Report of the Head of Development Management and Building Control

Address: 85 YEADING LANE HAYES

Development: Conversion of roof space to habitable use to include a rear dormer, 2 front roof lights, and a new gable end window (Application for a Certificate of Lawful Development for a Proposed Development)

LBH Ref Nos: 4359/APP/2025/1471

SITE ADDRESS:	
85 YEADING LANE, HAYES UB4 0EW	
DRAWING TITLE:	
DRAWING TITLE:	PROPOSED ELEVATIONS
SCALE:	1:100 @ A3
DATE:	08-05-2025
DRAWING NO:	25/YL85/004
REV

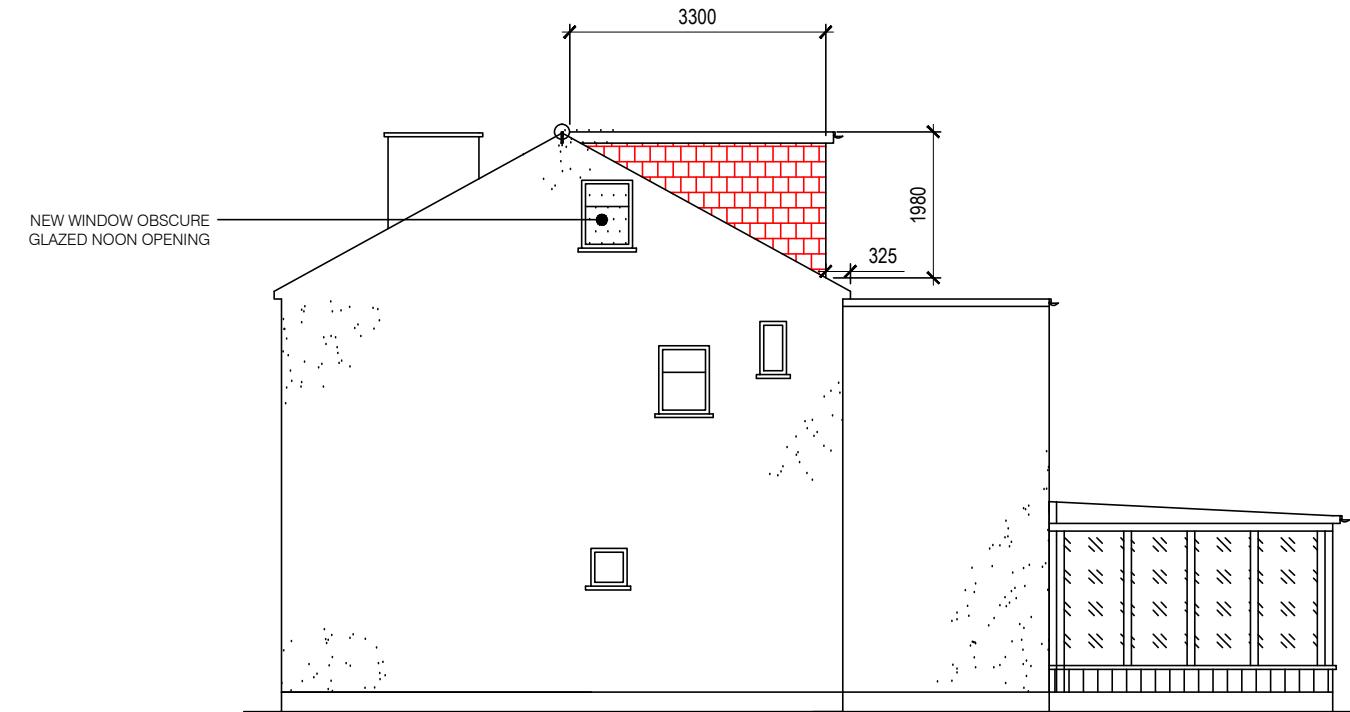
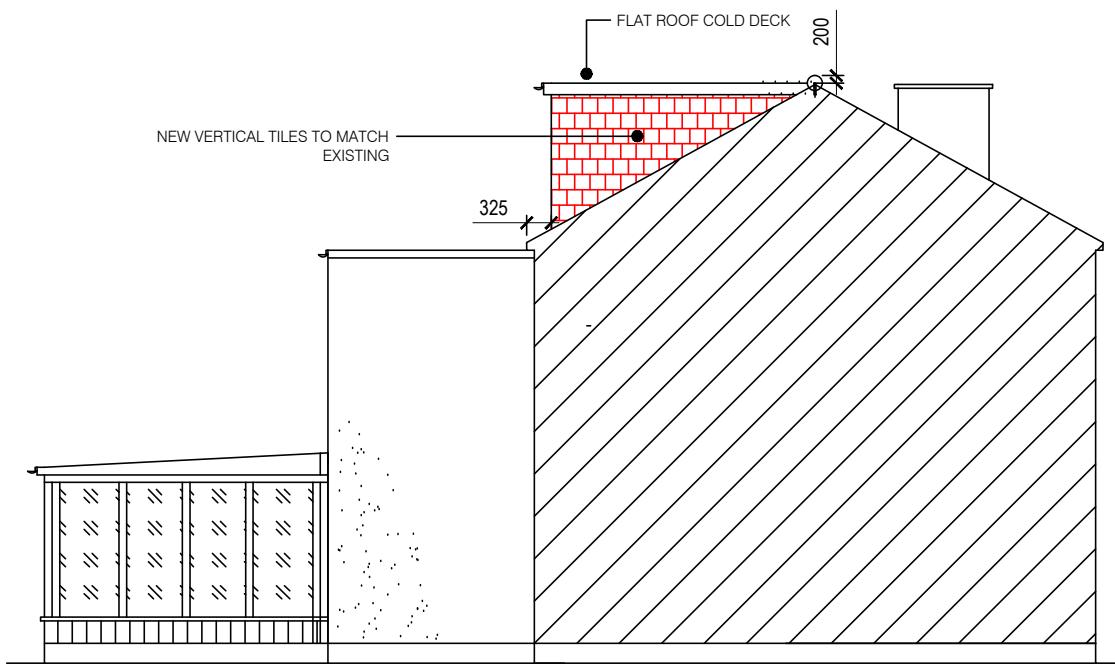
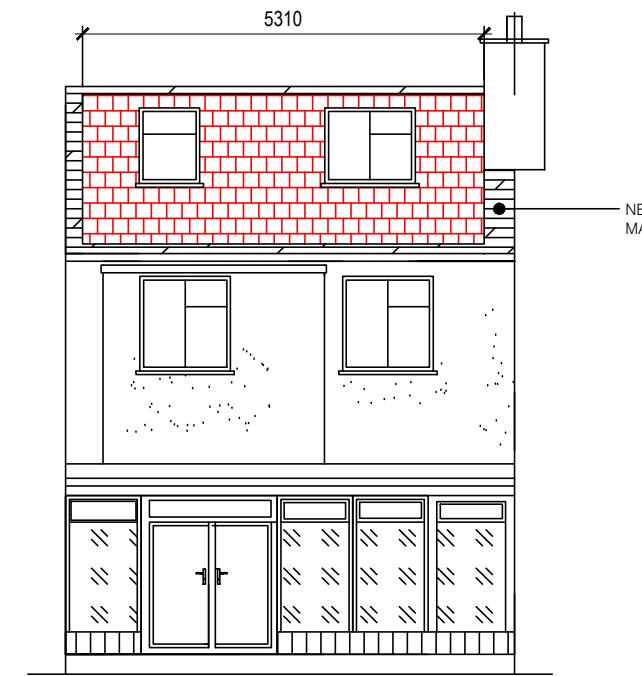
Are any side facing windows obscurely glazed and non-opening (unless the parts of the window which can be opened are more than 1.7 metres above the floor of the room in which the window is installed)?

YES - stated in drawing no. 25/YL85/004
